January 6, 2025

Hannah Aulick
Senior Planner
City of Albuquerque
Parks and Recreation Department

Re: [Review - PR-2024-009956 Taco Bell](#)
[Comment Responses to Parks & Rec Development Review](#)

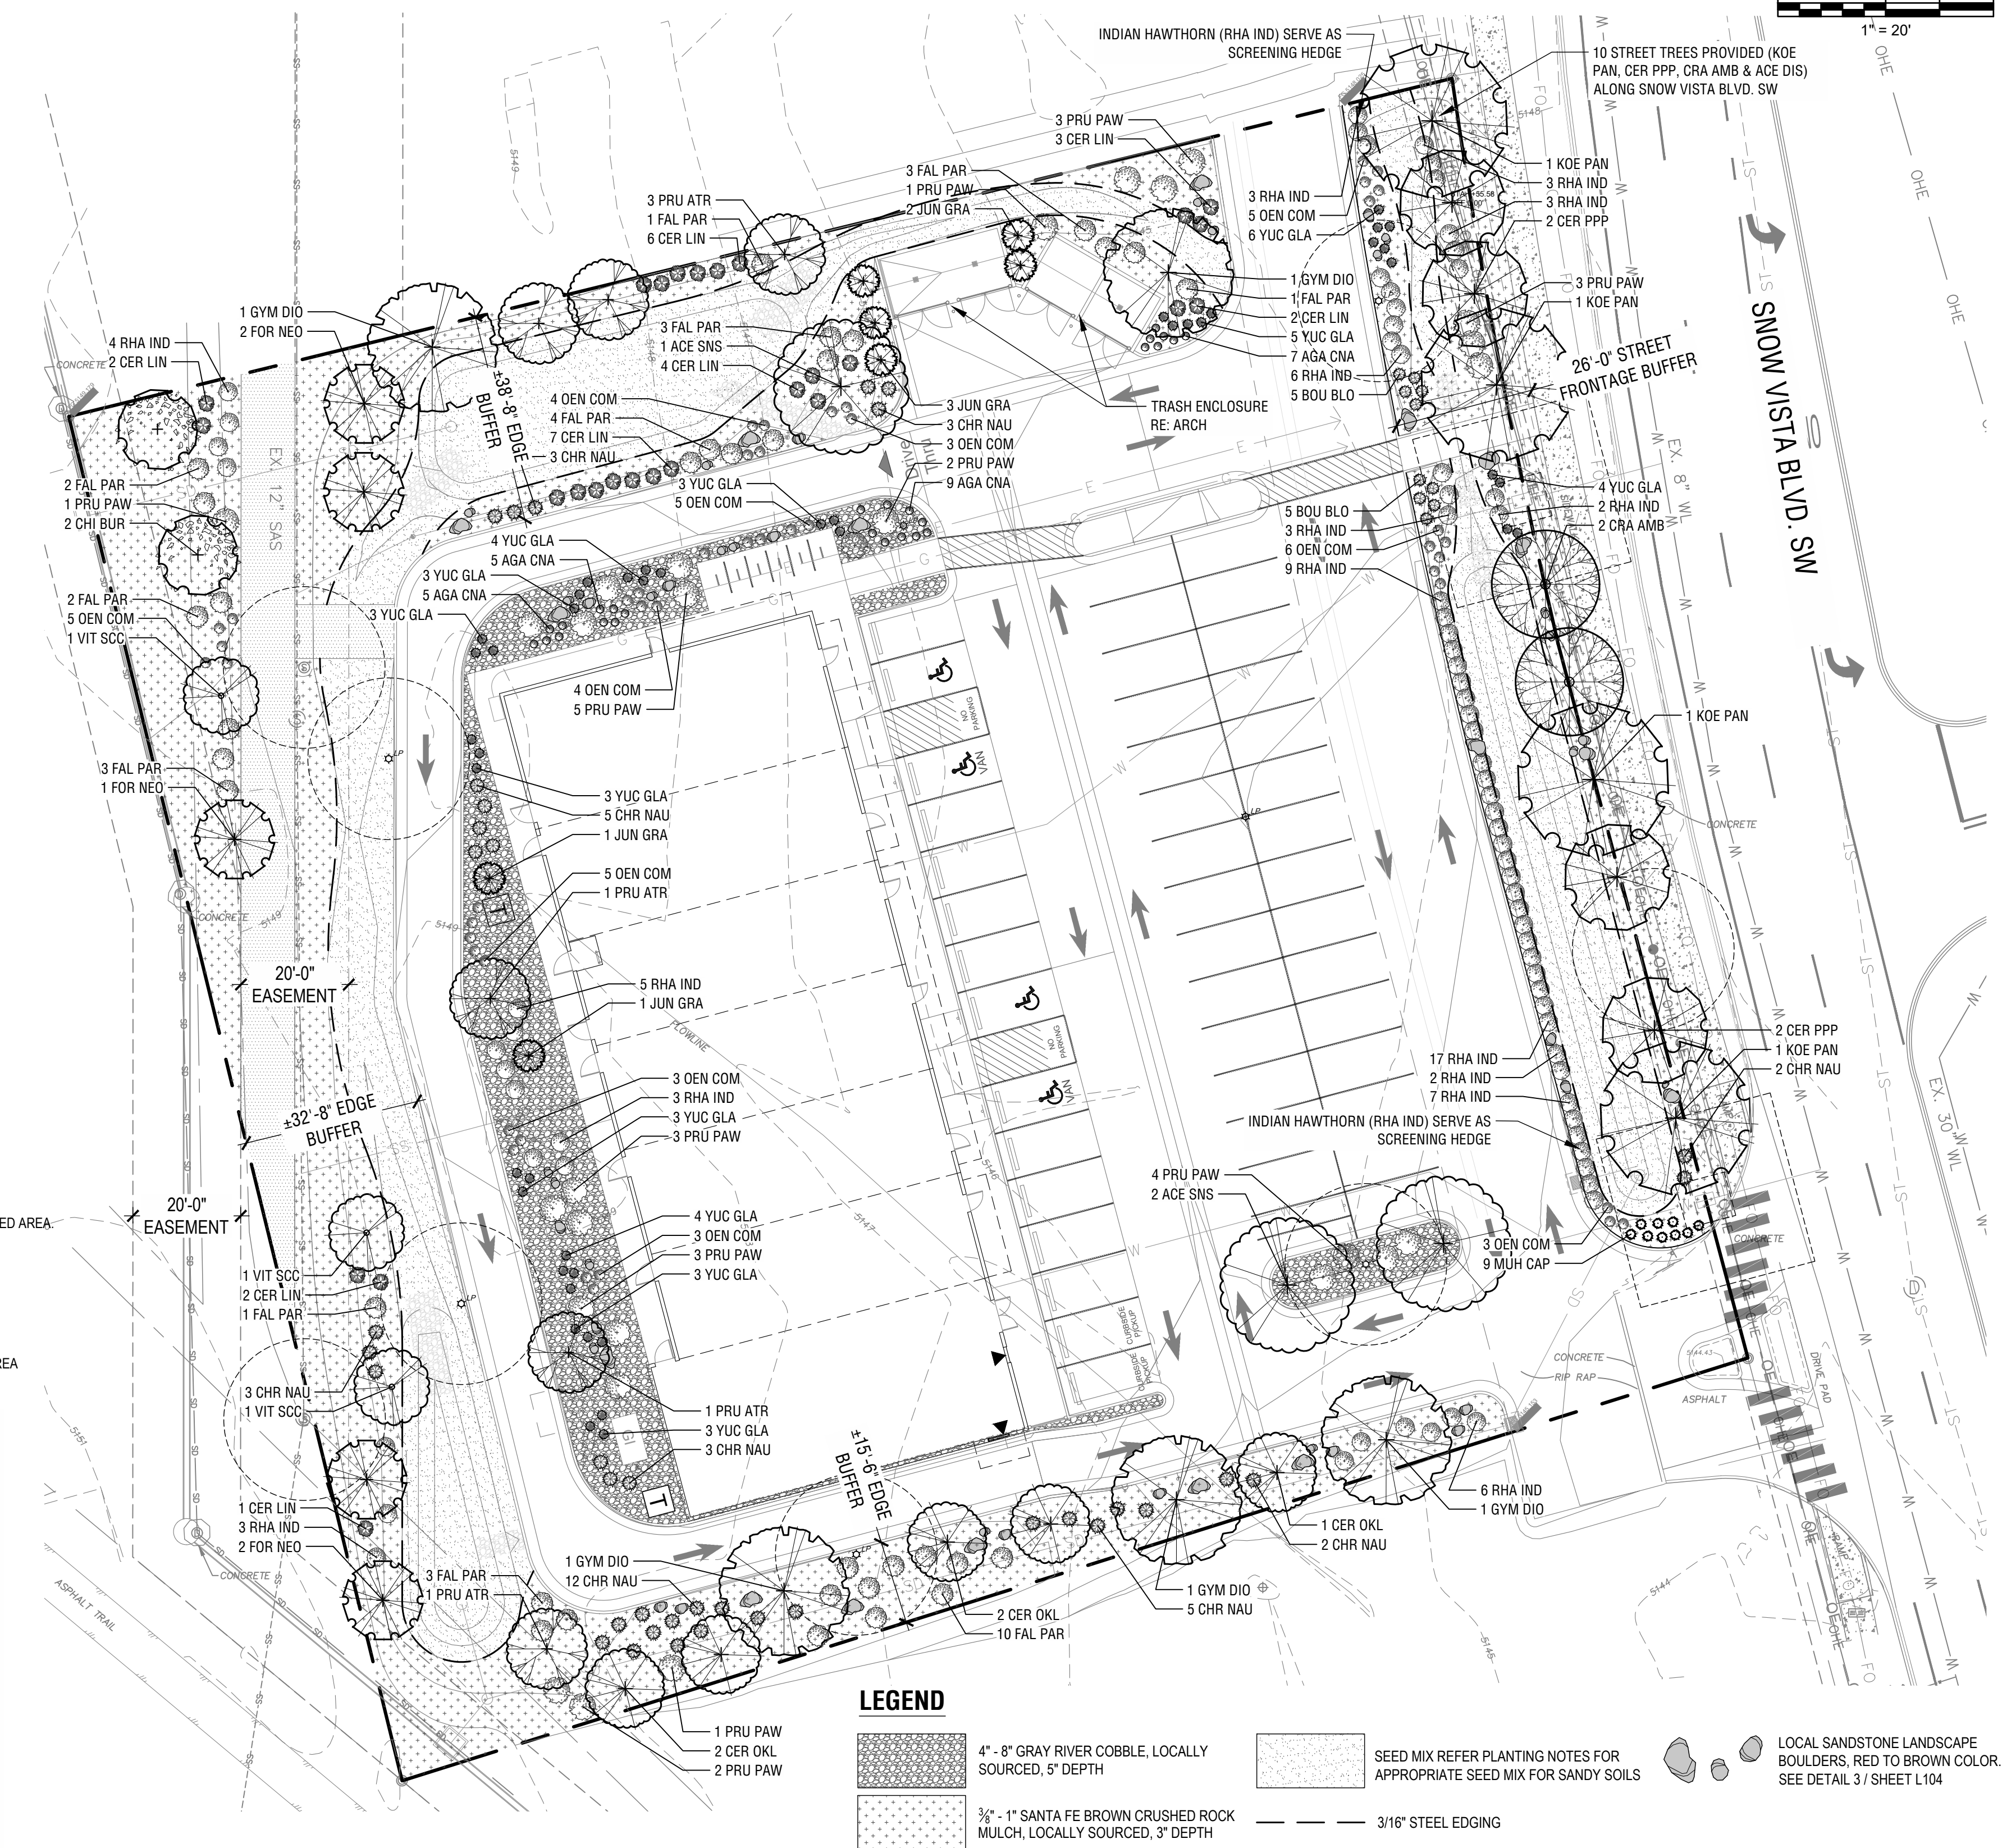
- **Response: Trees are planted minimum of 12 feet clear of existing or proposed street light poles.**
5. Per City Forestry, where overhead distribution lines exist, smaller trees such as Goldenrain tree, Pink Pompoms Redbud and Russian Hawthorn must be used. Please check this item along Snow Vista Blvd.

- **Response: Small trees, and suggested species are used under overhead distribution lines.**
6. Street Trees: Trees are generally required along street frontages every 25 feet on center unless specified otherwise in Part 6-6-2 of ROA 1994 (Street Trees). Along street frontages where street trees are required, trees that are planted within 20 feet of the back of curb of the abutting street may fulfill this requirement. Compliant. Consider alternating the street trees to avoid any future spread of disease among same species. Please note the previous comment on this page.

10. Consider adding some native xeric evergreen shrubs, and native xeric trees along the western edge of the project to provide some buffer for the paved multi used trail adjacent to the site. Such as Chamisa, Apache plume, Rosemary etc. for shrubs and Desert willow, Vitex, and New Mexico Olive etc. for trees. Please see the marked-up image below for your reference.

- **Response: Trees species are alternating to avoid spread of disease.**
7. Per 5-6(C)(5)(e) Organic mulch is required as ground cover under trees within a 5-foot radius around the tree trunk, but not directly against the trunk. In these areas, weed barrier fabric is prohibited. The 5' radius organic mulch must be shown and called out on all tree planting details. Please see the figure below from the IDO 5-6(C)(5)(e) for more clarification.

- **Response: Xeric planting provided in areas not restricted by easements delineated on plan.**
